Subject: RE: Planning Consultation on: BR/79/21/PL

Application No: BR/79/21/PL

Site Address: 83 Aldwick Road Bognor Regis PO21 2NW

Description of Works: Rear extensions and loft conversion to form enlarged HMO (Sui Generis) (resubmission following BR/206/19/PL).

amendments	
client	SPP
project	83 Aldwick Road Bognor Regis PO21 2NT
project ref.	2446
drawing title	Existing plans
drawn by	DH
date	DEC 20
scale	1:50/100@ A1
	www.bpmnet.co.uk info@bpmnet.co.uk
Do not scale off drawing, check all dimensions on site before all work is commenced

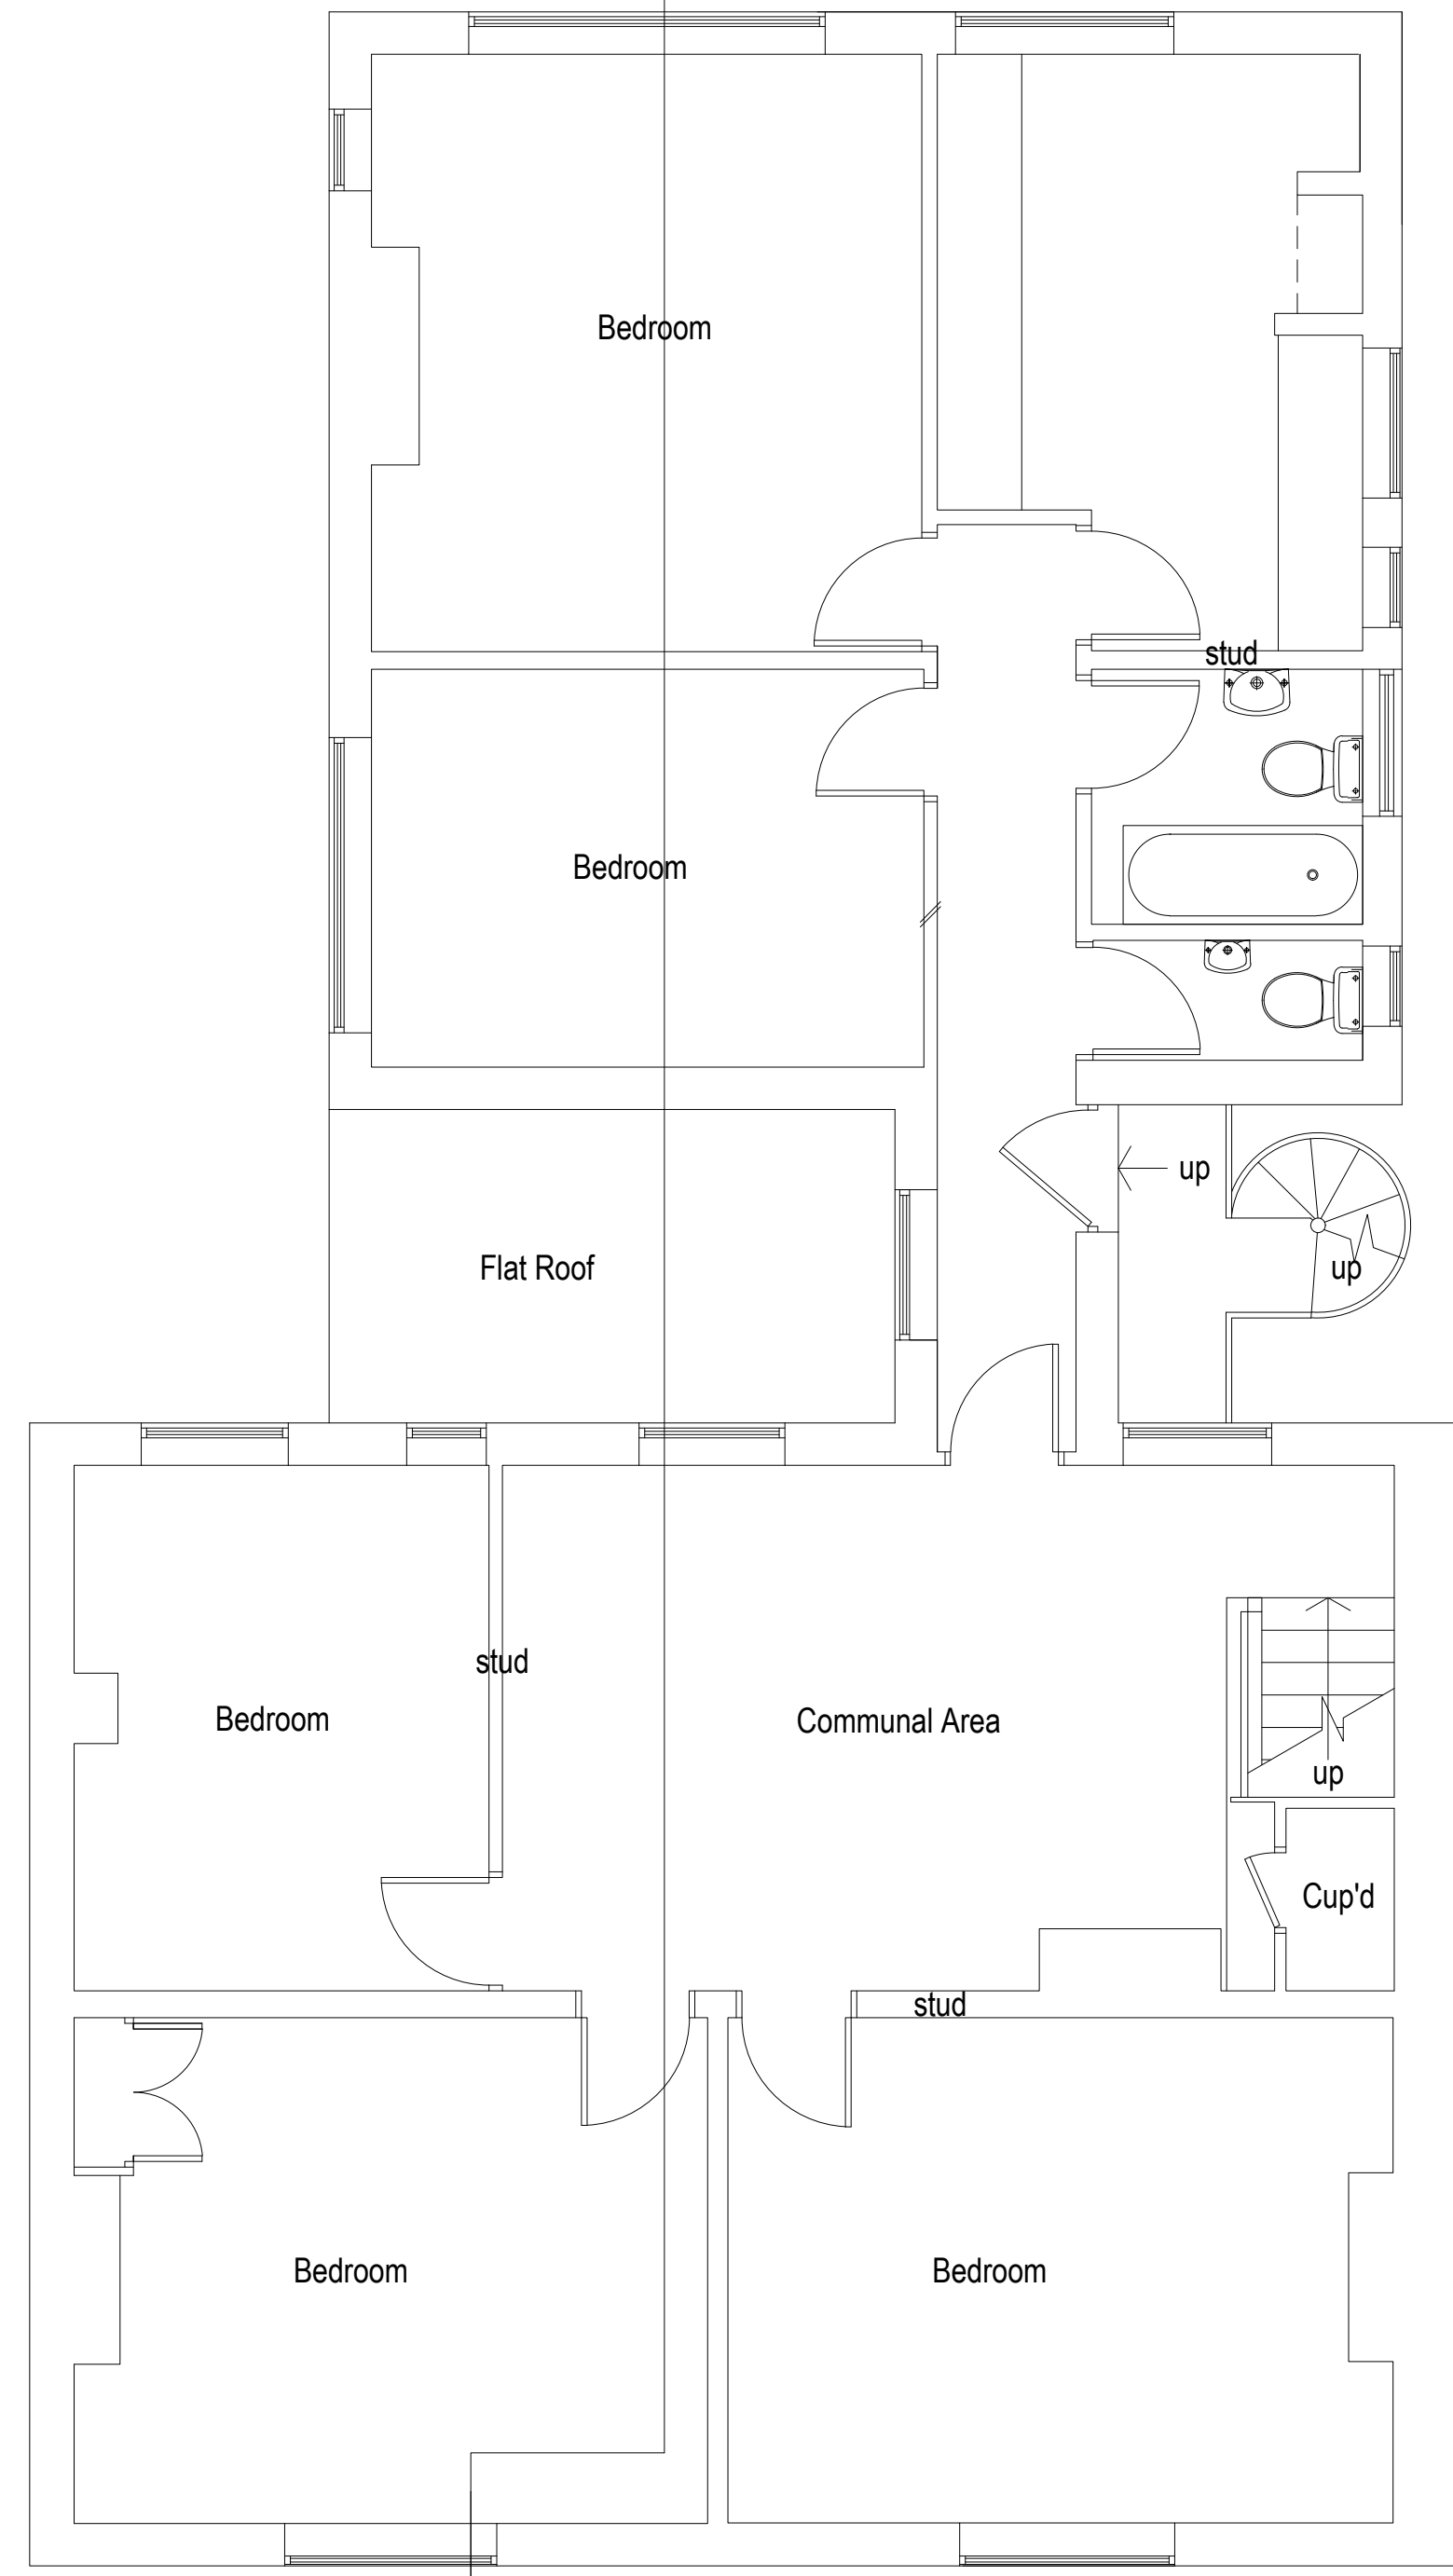
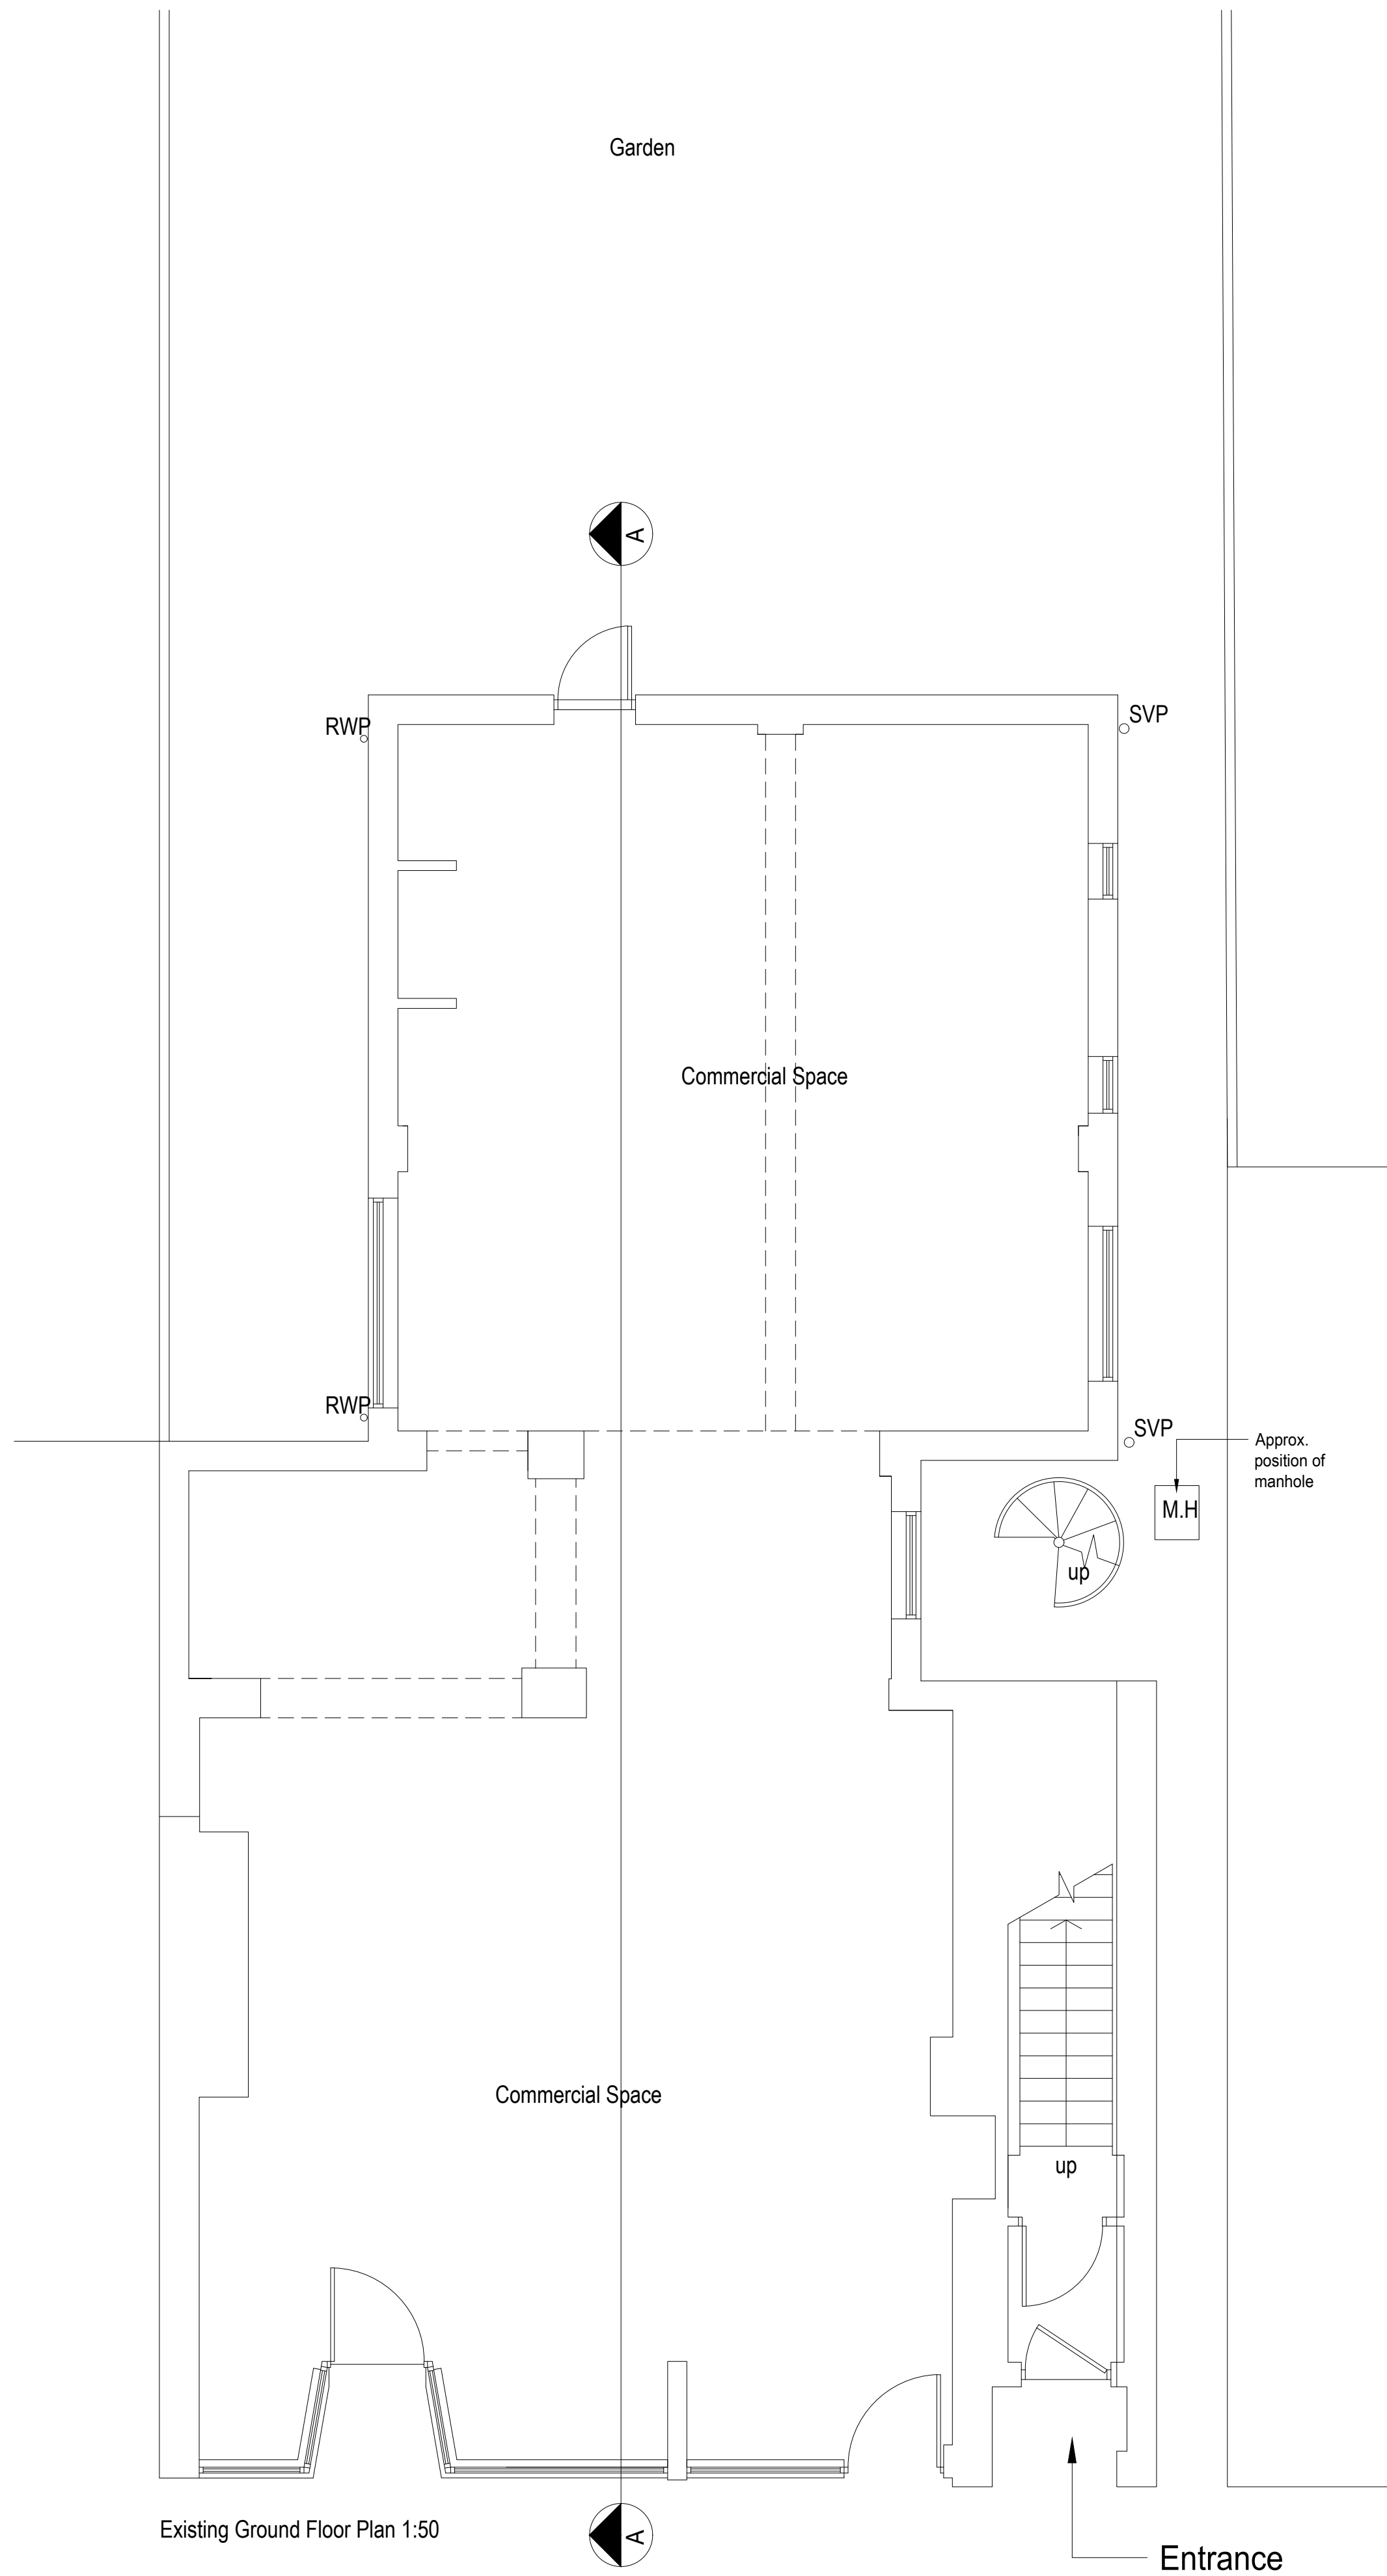
- The bedrooms on the second floor to the North side of the property only have skylights/roof casements available. As they appear to be the only source of light and ventilation within these rooms, they must meet all of the following criteria:

- Must be able to be fully opened for ventilation during spells of prolonged and heavy rain or snow without allowing it to enter the room;
 - Must have integral passive ventilation even when the window is shut; and

- Must provide a reasonable view. The Housing Health and Safety Rating System (HHSRS) states as a relevant matter that there should be a “reasonable view out of all rooms, other than those where privacy is required, such as bathrooms and WCs”, as this can have a negative effect on mental health, especially over the longer-term

Proposed ground floor layout.

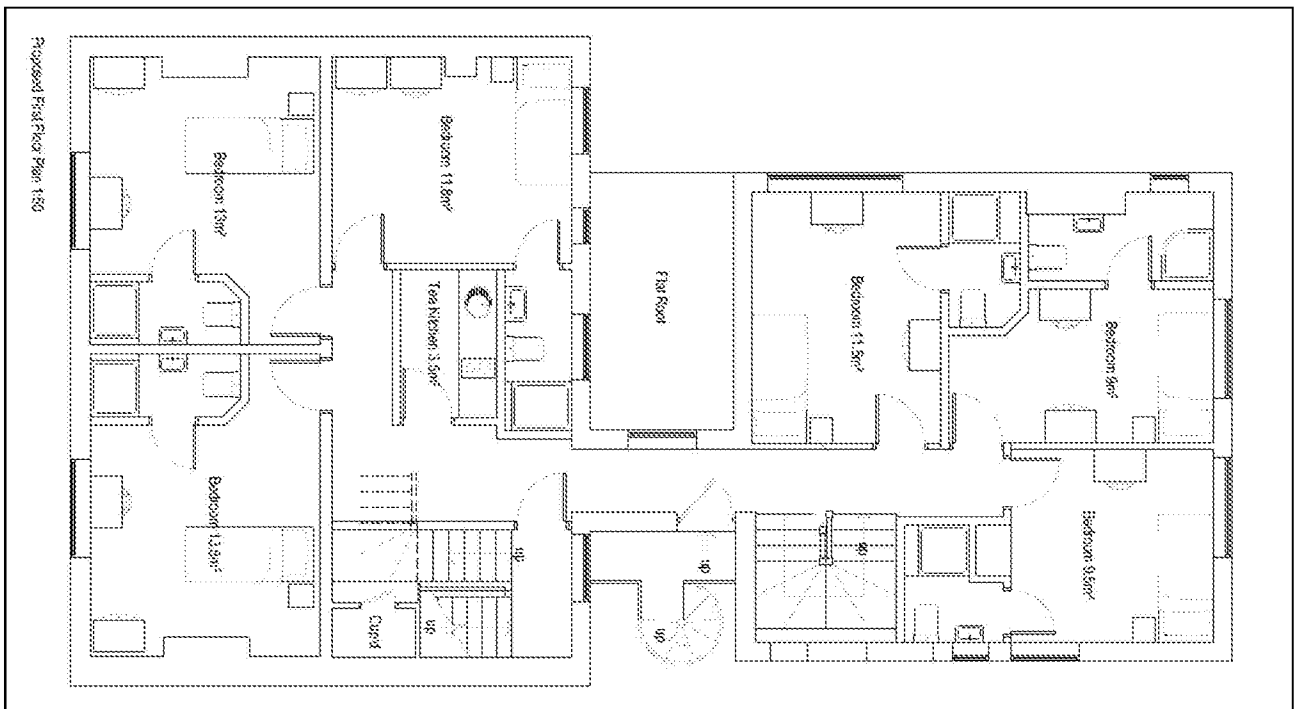
- Interlinked heat detection to the communal kitchen on the ground floor
 - Interlinked heat detection to the communal tea kitchen on the first floor
- Fire blankets should be provided to all kitchen areas

- Any property that has 5 or more people sharing facilities will require a licence from the Council and the property must meet minimum standards
- The amenities provided within the communal kitchen will need to be sufficient to accommodate the number of occupants; such as cooking and washing provisions. This also includes sufficient worktop space where the minimum size required is 500mm (L) x 600mm (D) per user. The current proposal for the kitchen layout does not appear to be adequate in terms of meeting the HMO standards. Consideration should be given to extending the kitchen facilities within the communal room

- Kitchens should have adequate mechanical ventilation
- Mechanical extraction should be provided to all bathrooms/shower rooms/en suites. This extends to the separate WC compartment on the ground floor as there is no openable window.

Proposed first floor plan.

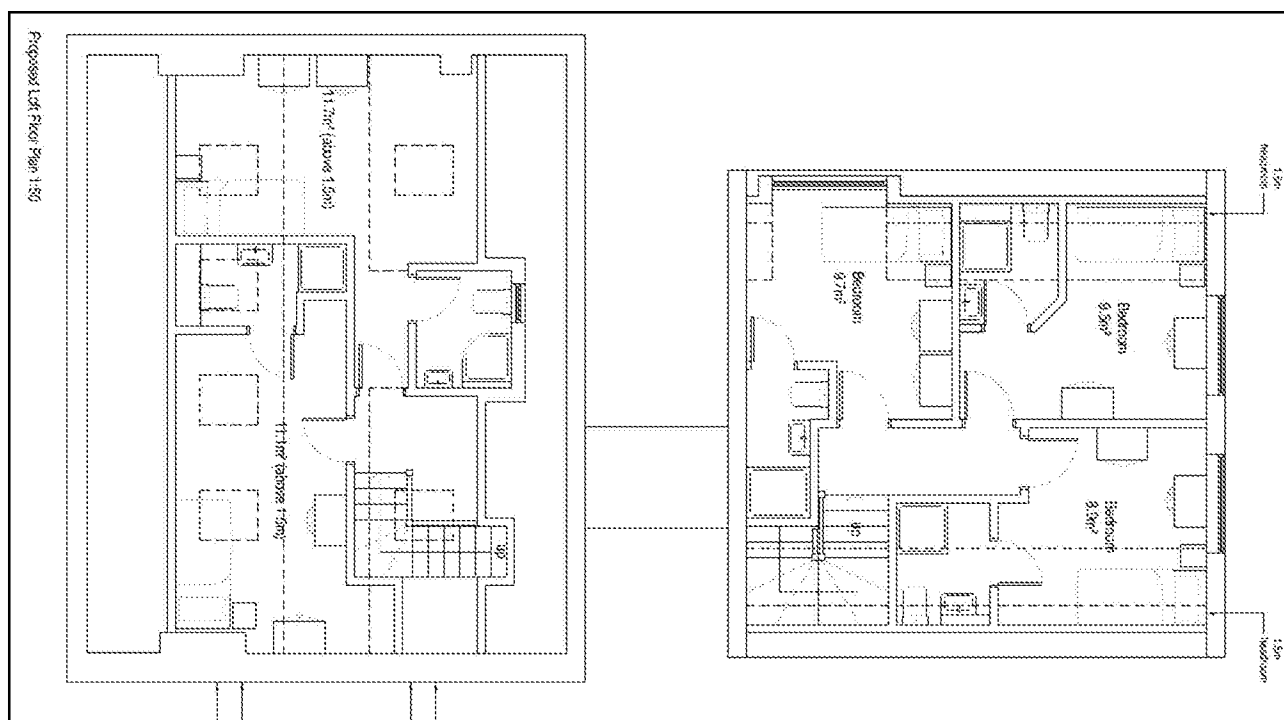
- The under stairs cupboard to the first floor landing should afford 30 minutes fire resistance. The floor, door, ceiling and walls, including the spandrel wall, must be free from holes and lined with a material that has an integrity of 30 minutes fire resistance. The cupboard must be kept free from belongings and the door locked at all times
